From: Paul Cann
Sent: 13 October 2017 15:02
To: Planning.Responses
Subject: RE: Planning Consultation on: EP/138/17/PL

Engineers comments in respect to surface water drainage:

APPLICATION EP/138/17/PL

Description of Works: Demolition of existing buildings & erection of 3 no. dwellings
with associated parking, alterations to existing access &
relocation of staircase to flats

Proposed Site Plan, Block Plan
and Location Plan

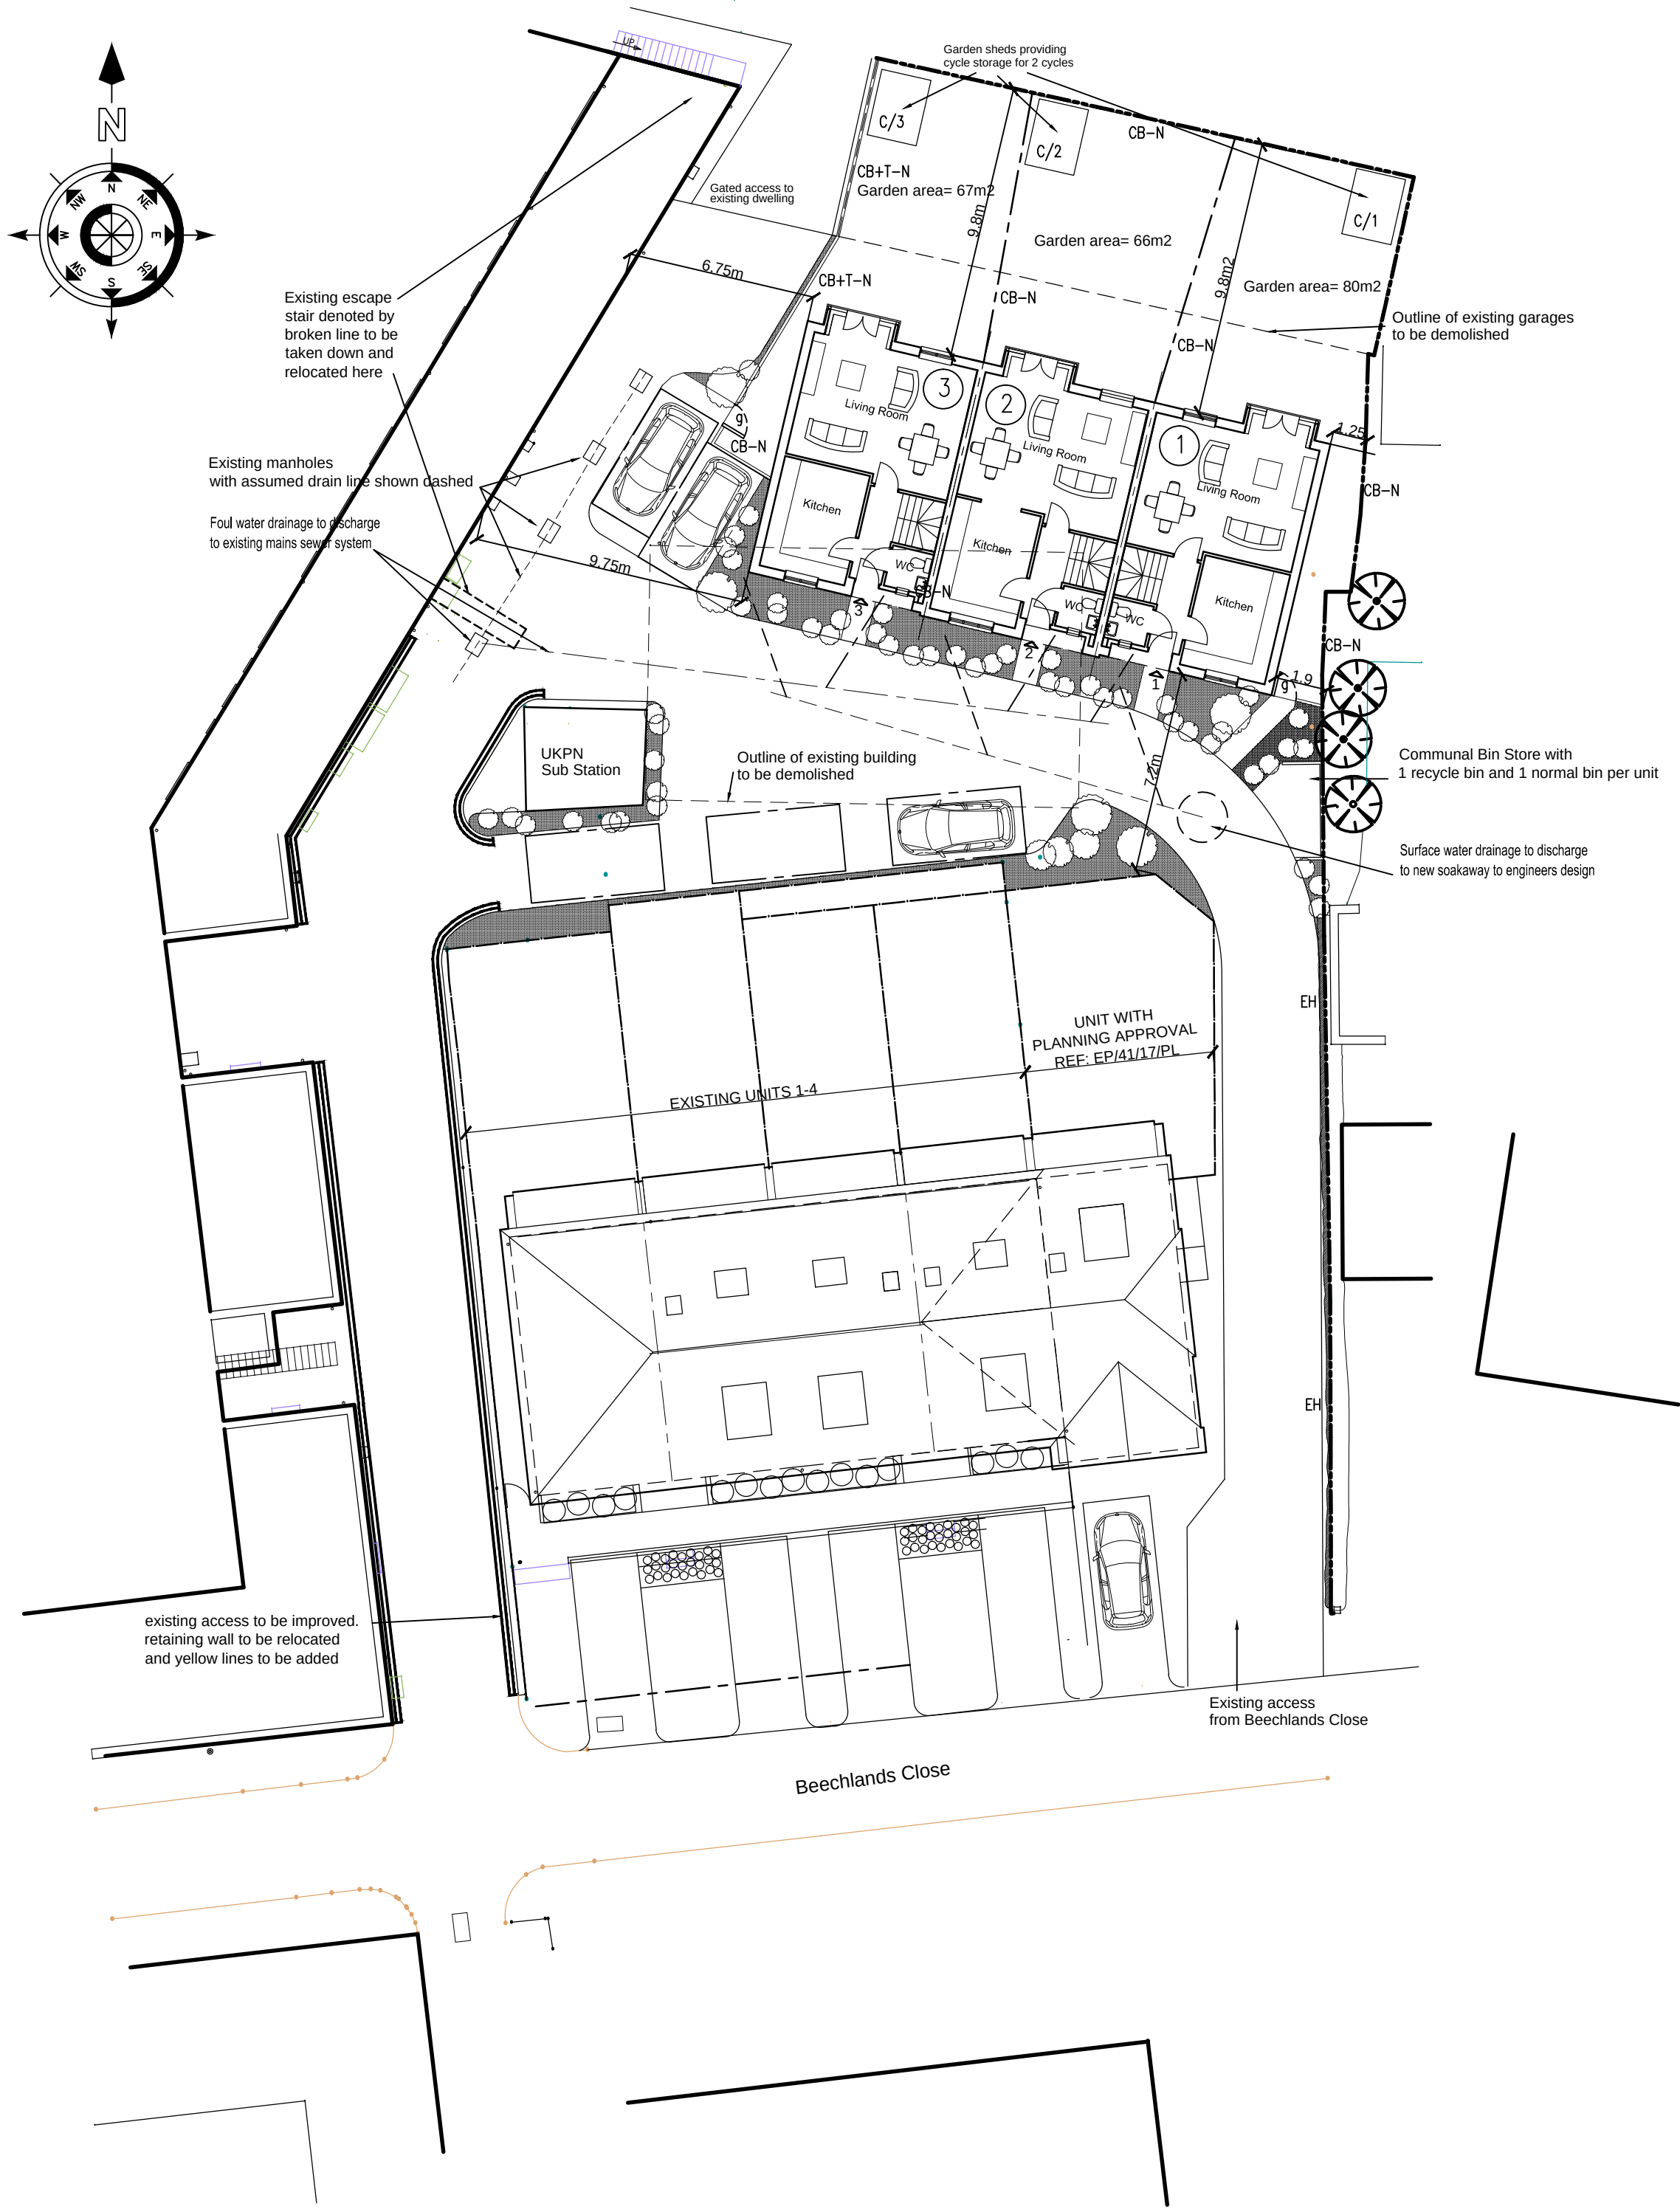
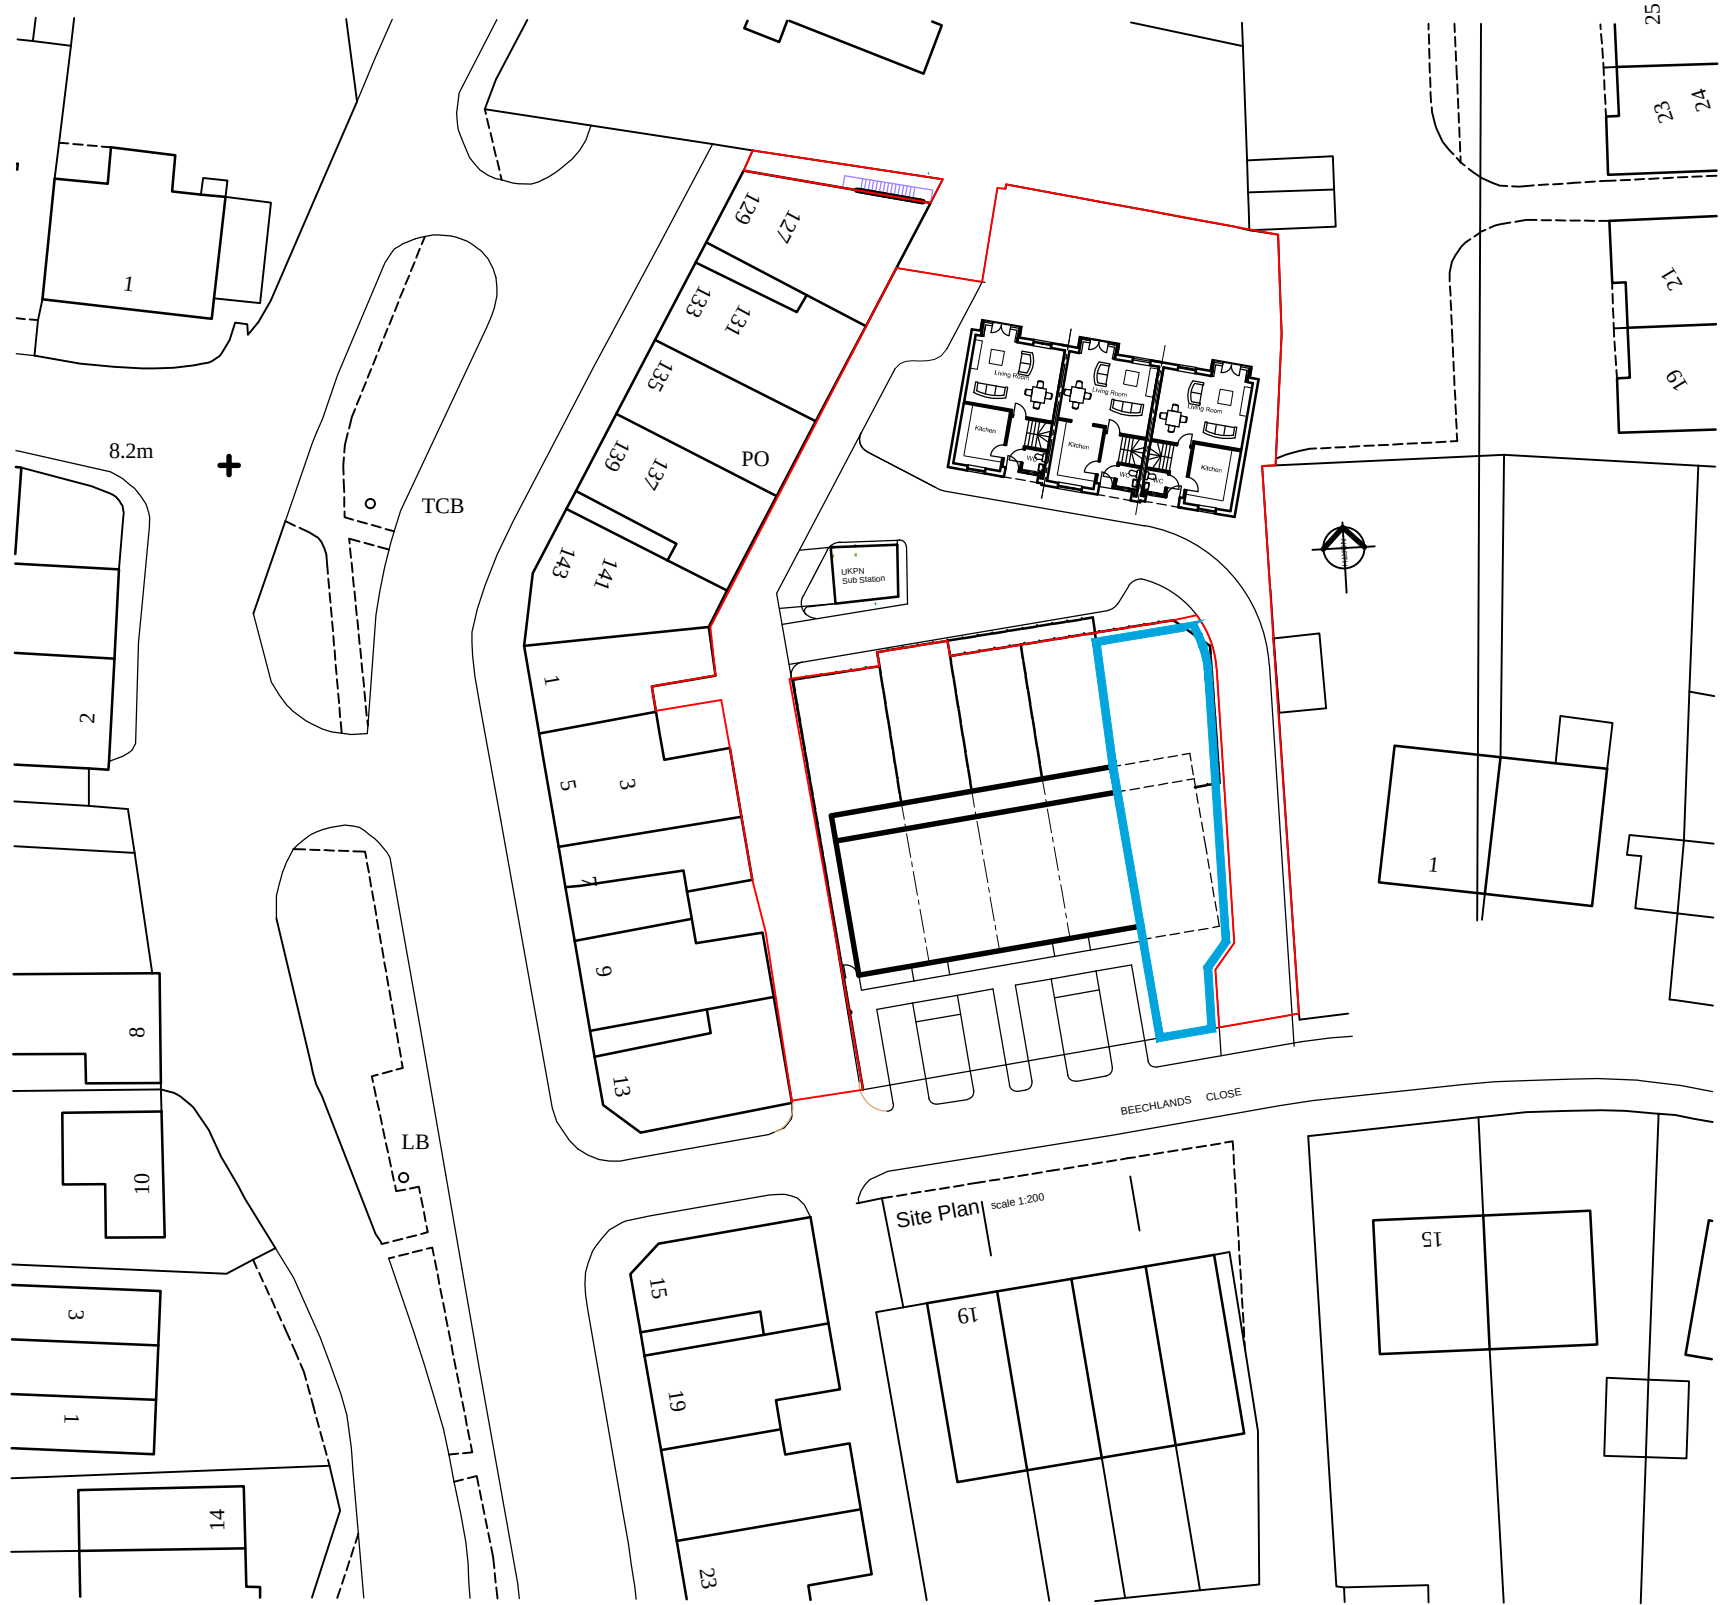
Soakaways must be investigated for surface water disposal.

Infiltration rates for soakage structures are to be based on percolation tests undertaken in the winter period and at the location and depth of the proposed structures. The percolation tests must be carried out in accordance with BRE 365, CIRIA R156 or a similar approved method and cater for the 1 in 10 year storm between the invert of the entry pipe to the soakaway, and the base of the structure. It must also have provision to ensure that there is capacity in the system to contain below ground level the 1 in 100 year event plus 30% on stored volumes, as an allowance for climate change. Adequate freeboard must be provided between the base of the soakaway structure and the highest recorded annual groundwater level identified in that location.

Any SuDS or soakaway design must include adequate groundwater monitoring data to determine the highest winter groundwater table in support of the design. The applicant is advised to discuss the extent of groundwater monitoring with the Council's Engineers. Supplementary guidance notes are also enclosed for information.
